CITY OF ALBUQUERQUE

**RE: Kirkpatrick Warehouse (File: C17D122)
Grading and Drainage Plan, Engineer's Stamp Date 2-5-15
Drainage Report, Engineer's Stamp dated 11-25-14**

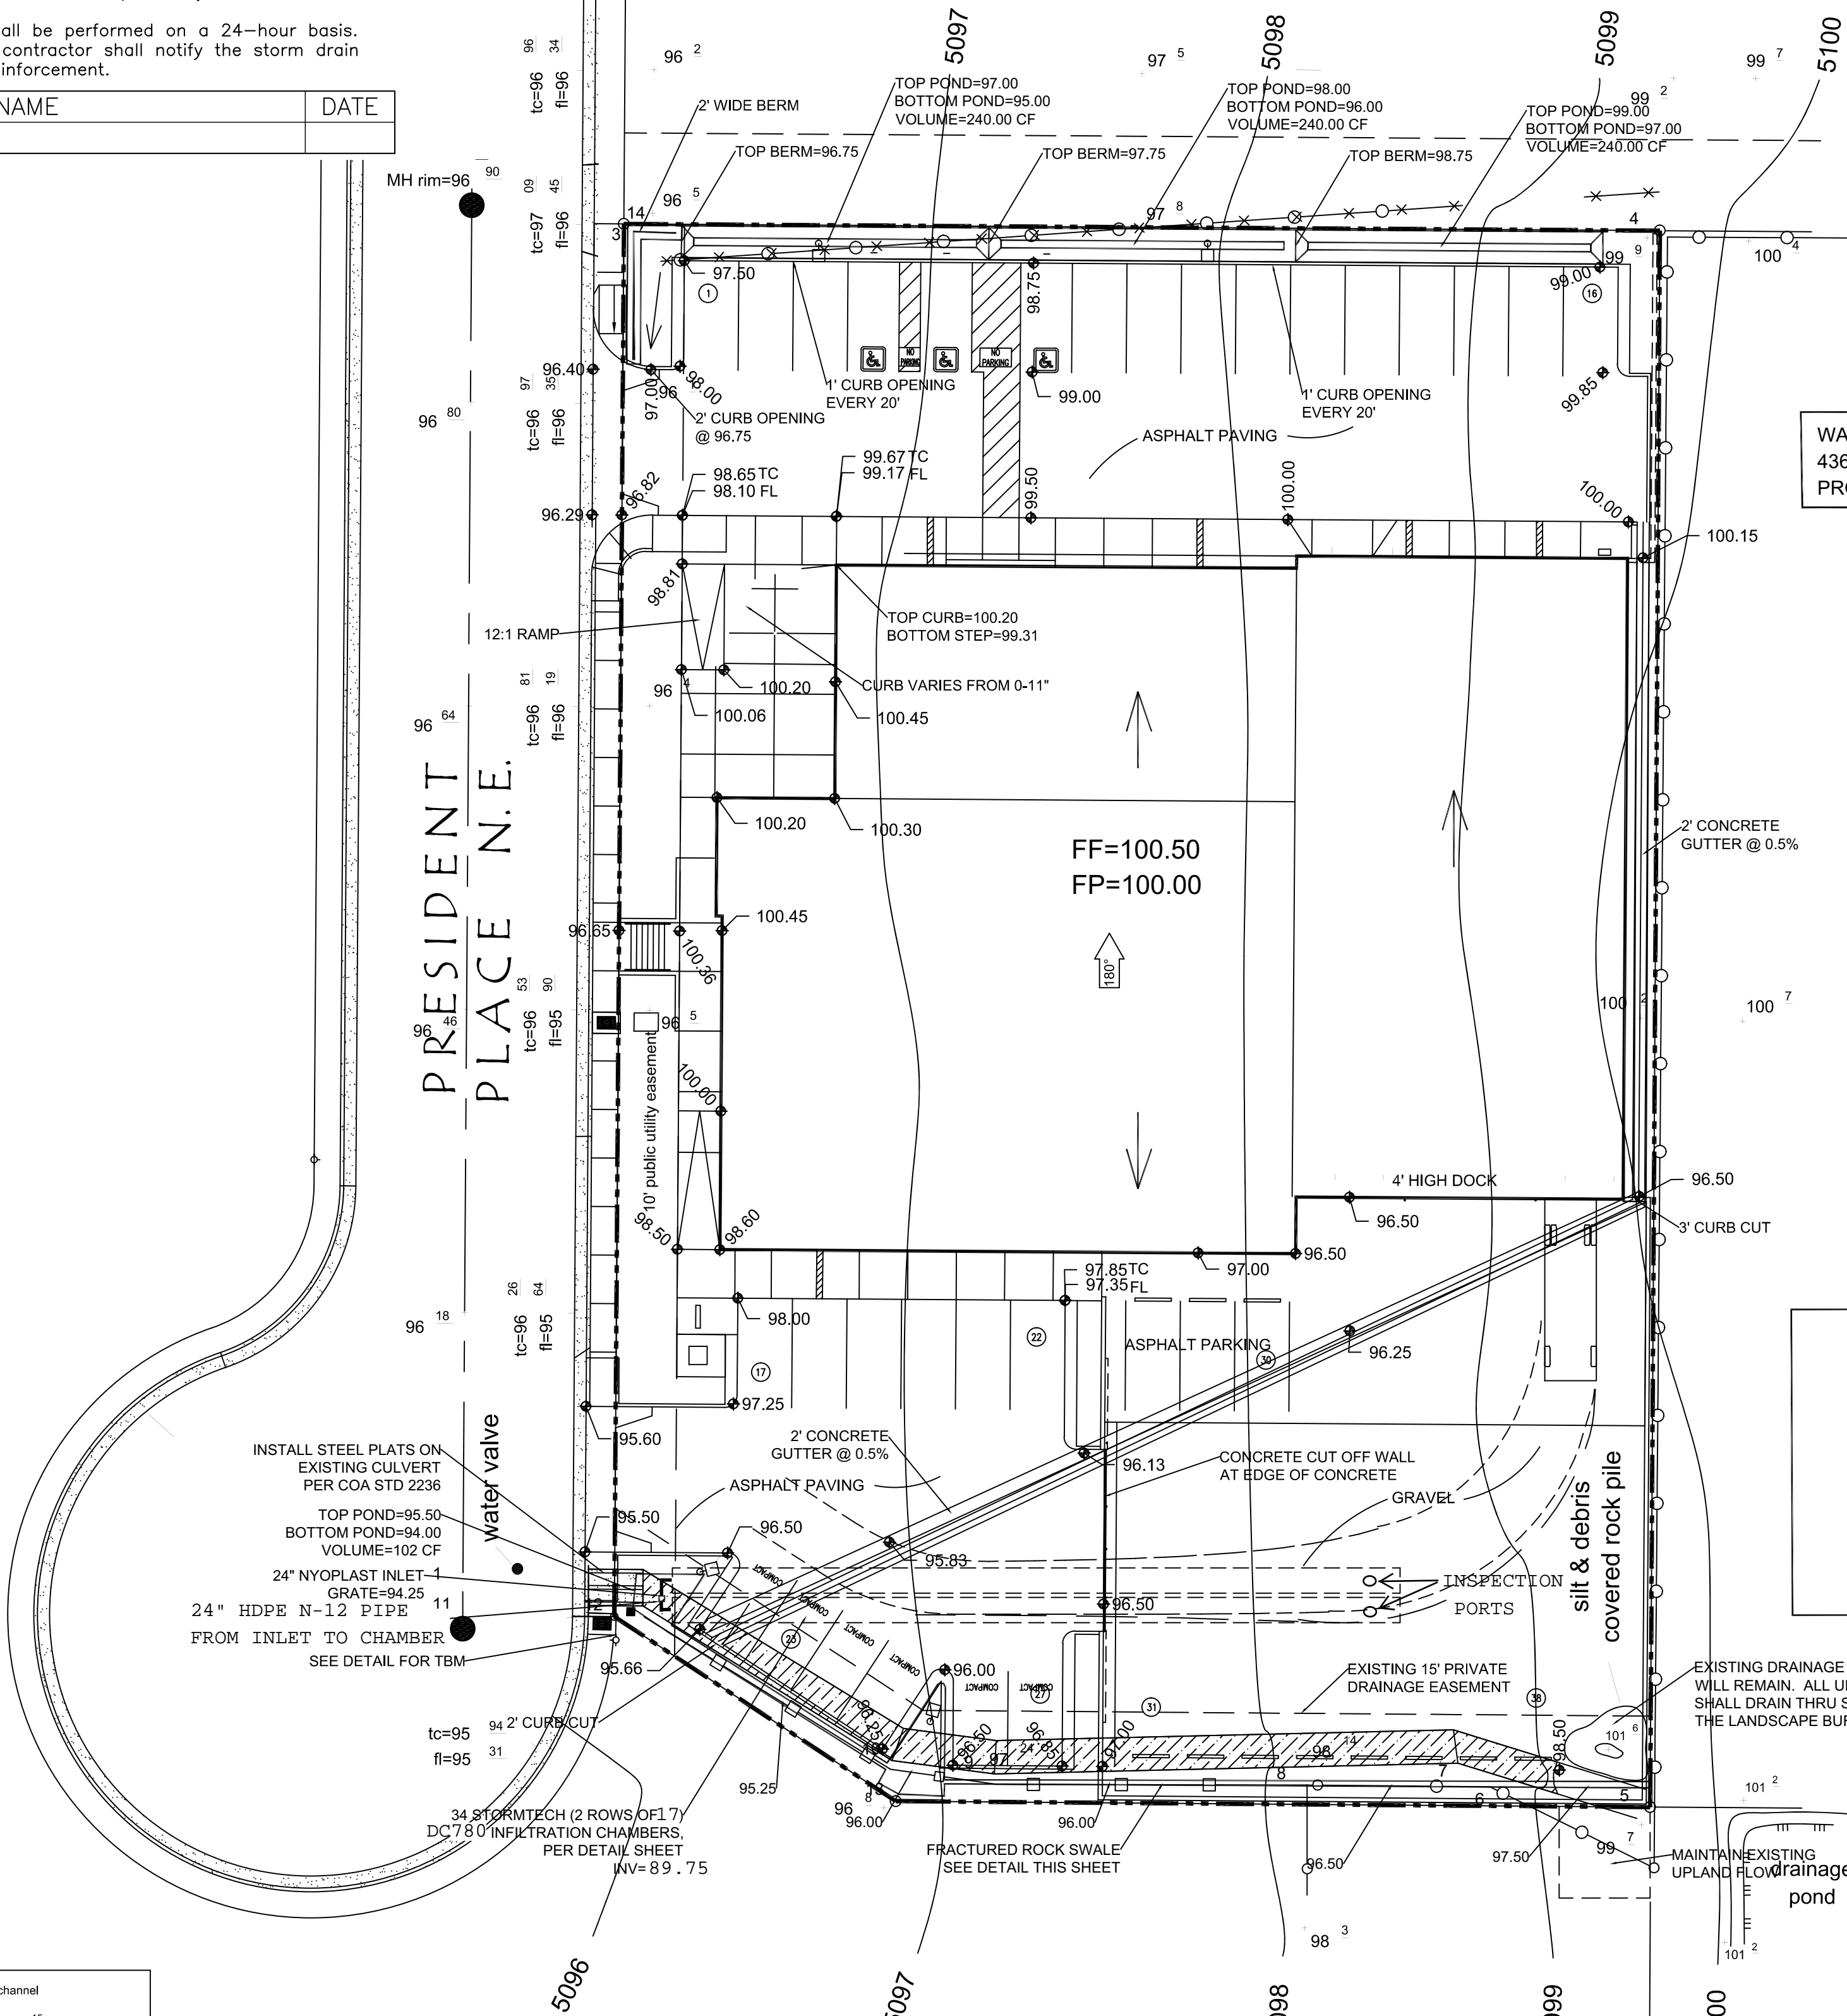
- Add rip-rap where the drainage channel along the south side discharges to the retention pond.
- Note that the fence is to be removed.
- Limit the diameter or size of any landscaping that is to be put within the channel so that the capacity of the channel is not reduced.
